An
Bord
Pleanála

Inspector's Report ABP-309852-21

Whether (1) the making of a small opening in the wall between Belmont Lawn and Ardagh Crescent, and (2) the construction of a short section of pathway across the lawn to link to the existing pathways across Belmont Lawn, is or is not development or is or is not exempted development.

Boundary wall between Belmont Lawn and Ardagh Crescent, Blackrock, Dublin.

ELEVATION OF WALL FROM ARDAGH CRESCENT

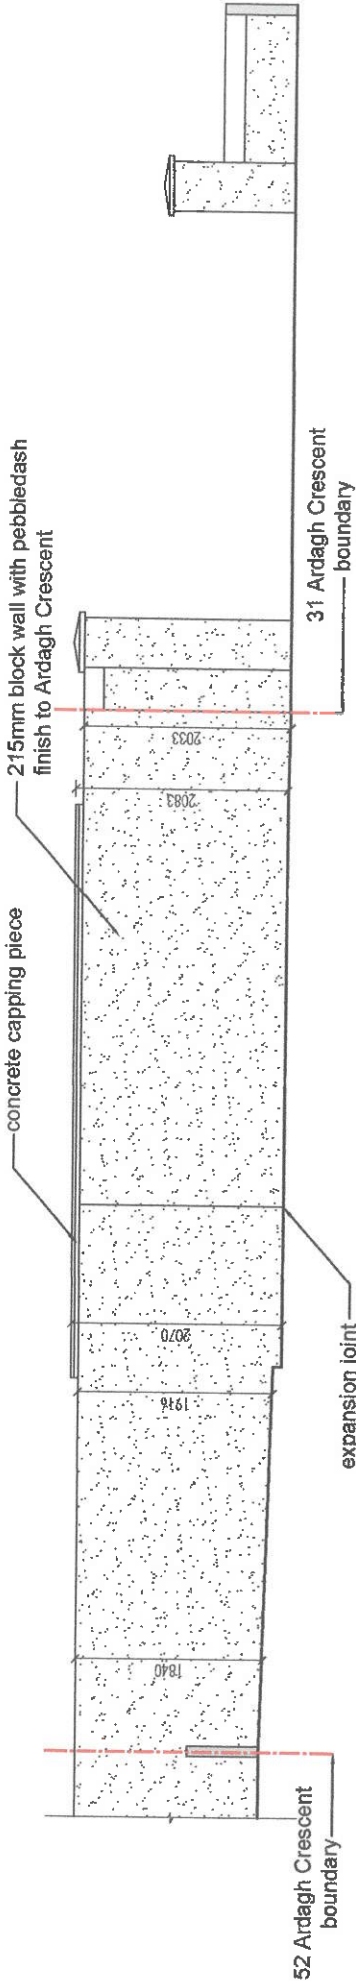
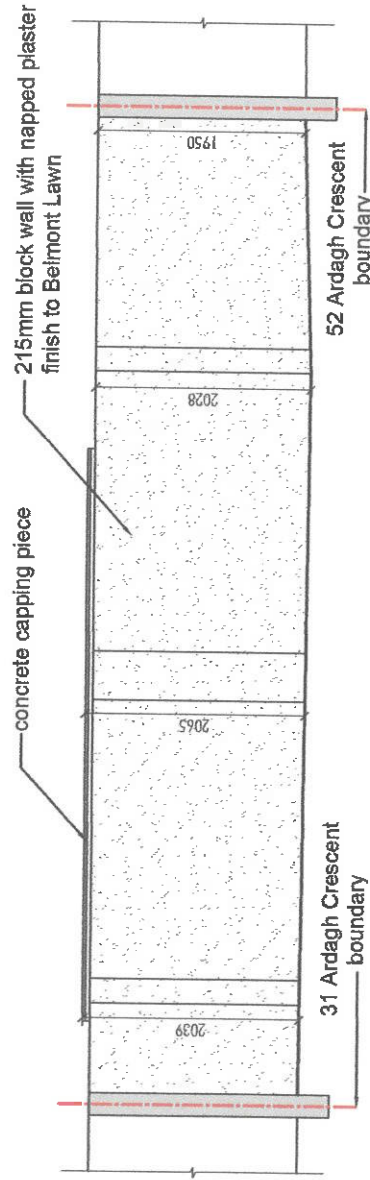
Following the receipt of a response to a request for further information, a second report was prepared which noted that while the scaled drawings supplied by the applicant had detailed the height of the boundary wall, no indication had been provided of the location of the wall opening itself. Given the variance in the height of the wall, it was stated that the Planning Authority is unable to make a determination on the matter. Therefore, it was recommended that clarification be sought as regards the location of the pedestrian connection through the boundary wall.

- 8.1.1. Regrettably, the plans and particulars submitted in support of the subject application do not provide sufficiently clear detail as to the exact nature, dimension, or location of the works proposed, however, notwithstanding these deficiencies, I would refer the Board to Section 3 of the Planning and Development Act, 2000, as amended, which defines “*development*” as the carrying out of any works on, in, over or under land or the making of any material change in the use of any structures or other land.
- 8.1.2. In my opinion, the making of a small opening in the boundary wall between Belmont Lawn & Ardagh Crescent and the construction of a section of pathway would involve an act of development having regard to Section 2 of the Act where “*works*” are defined as:

Act, 2000, as amended. Insufficient detail has been provided in the documentation submitted to the Board of the location, positioning, dimensions, and particulars of the works proposed. In the circumstances, it is, therefore, considered that the referral should not be further considered by the Board.
